City of Sydney

Our Ref : S076158.035

Your Ref: MP11_0092

Environmental Assessment for Sydney CityGrid Stage 2A(ii)

Bligh Street Facade -
Planning Submission

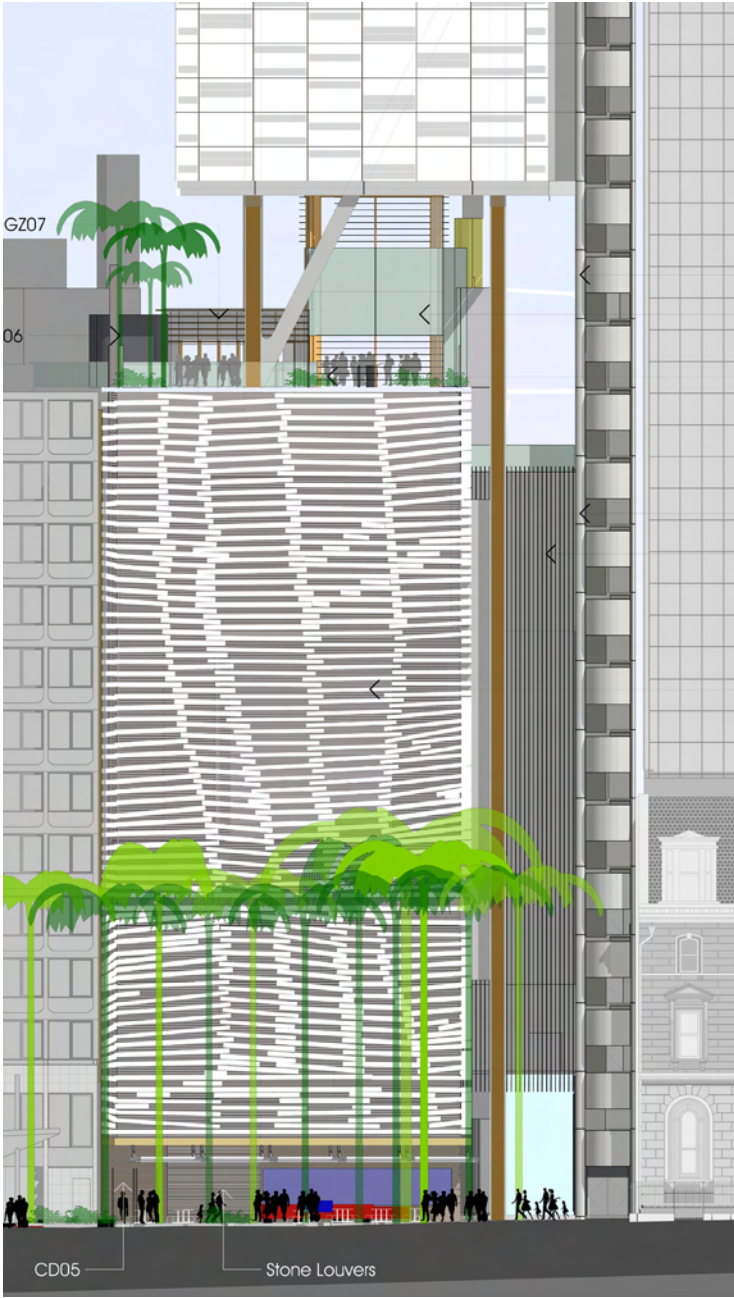
1. The Bligh Street wall sits forward of the former NSW Club. Consideration should be given to setting the building back to reveal more of the facade of the former NSW Club, particularly as viewed from the corner of Hunter and Bligh Street. In the photomontage the column from the tower appears to come forward of the former NSW Club building and thus over scales it. The column should be recessed into the entry.
2. Consideration should be given to improving pedestrian amenity and activation on O'Connell Street. This street is dominated by the two driveway crossings

7. In summary, the building should:
 - (a) not project beyond the predominant building line along O'Connell Street,
 - (b) be setback to reveal more of the former NSW Club on Bligh Street,

- (c) activate both Bligh and O'Connell Streets at ground level.
8. It is recommended that the design be modified to:
 - (a) Setback the stone facade of the electrical substation on Bligh Street to reveal more of the elevation of the former NSW Club.

- (b) Ensure that the column from the sky tower, is located within the recessed entry on Bligh Street (behind the line of the street wall) so as not to overwhelm the former NSW Club and the streetscape with its (super) scale.

O’Connell Street Facade -
Planning Submission

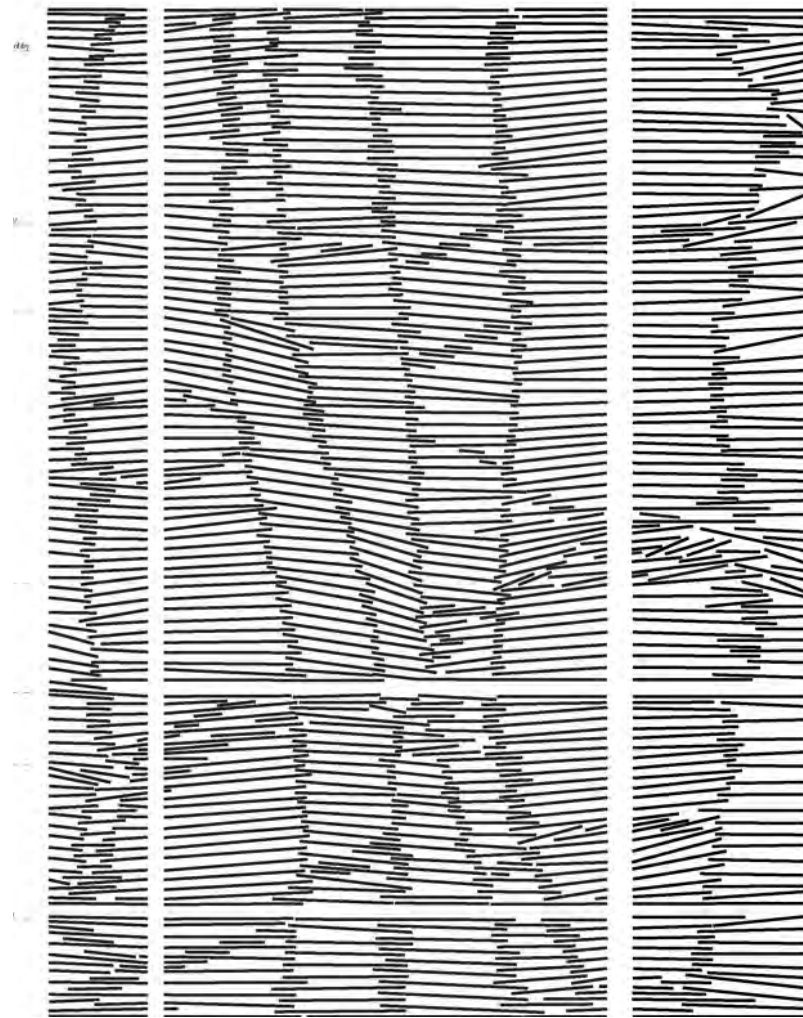
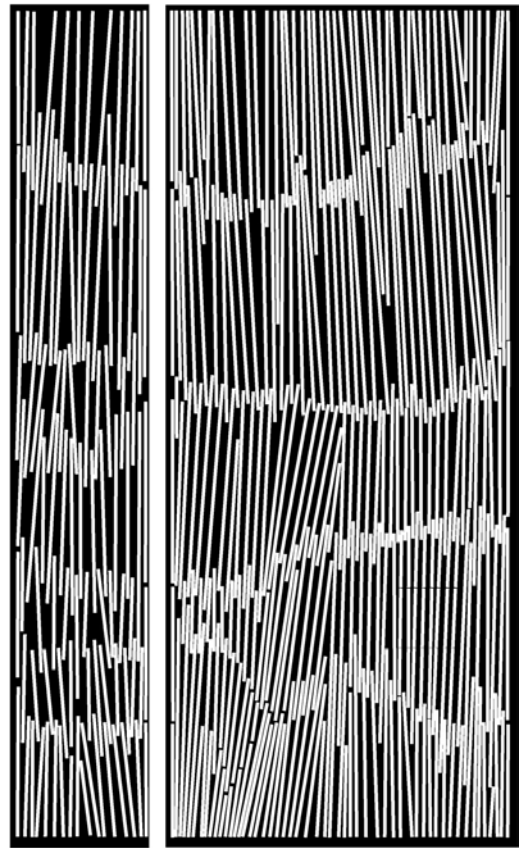
3. The proposed facade also sits forward of the adjoining buildings along O'Connell Street. The facade treatment of stone louvres has the effect of narrowing the street section and is inconsistent with the predominant building line along O'Connell Street. Although projections of a decorative nature (such as cornices, eaves, sills, mullions and architraves) are generally acceptable (up to 450mm), this should not be extended for whole facades up to the street wall height of the building.

5. Both facades to the electrical substation appear the same. The sandstone artwork for the O'Connell Street facade does relate to the vertical expression of the adjoining buildings 28-34 O'Connell Street and 16-18 O'Connell Street.

- (c) Setback the stone facade of the electrical substation on O'Connell Street to match the predominant build-to line. Projecting the stone facade
